## Farm at Neil's Creek Community – Lot 197

### STAIR LANDING FRAMING

M+K Project #: 126-22076 (01/03)

sheet:
S2.0

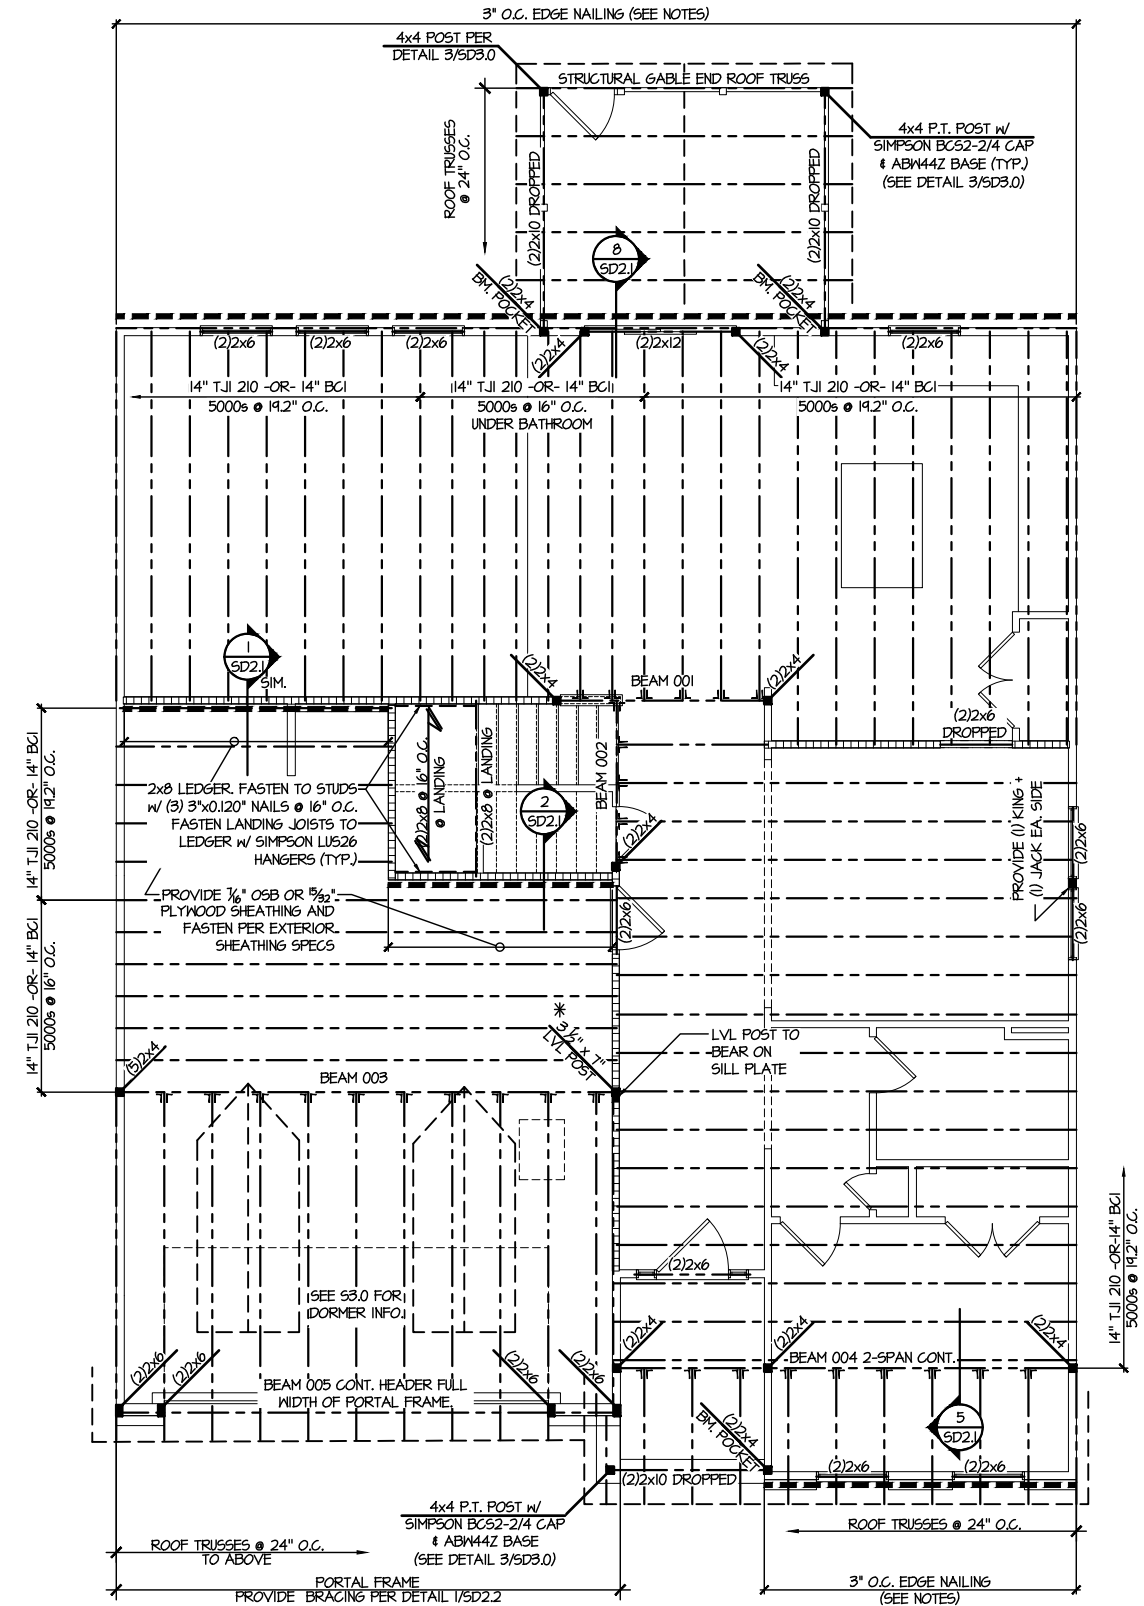
Pursuant to your request, we have prepared this letter to address an alternate framing method of constructing the stair landing that differs from the structural plans for lots in the above-referenced lot.

It is our professional opinion that the stair landing is structurally adequate to be framed with 2x8 joists pocketed into the bearing walls with full bearing on a 2x4 bearing wall stud below directly adjacent to a full height 2x4 bearing wall stud. Each 2x8 landing joist should be fastened at each end to the adjacent full height 2x4 bearing wall stud with (2) 3" long x 0.120" diameter nails. If a different as-built framing condition occurs other than this described case, please contact Mulhern & Kulp for additional analysis and documentation.
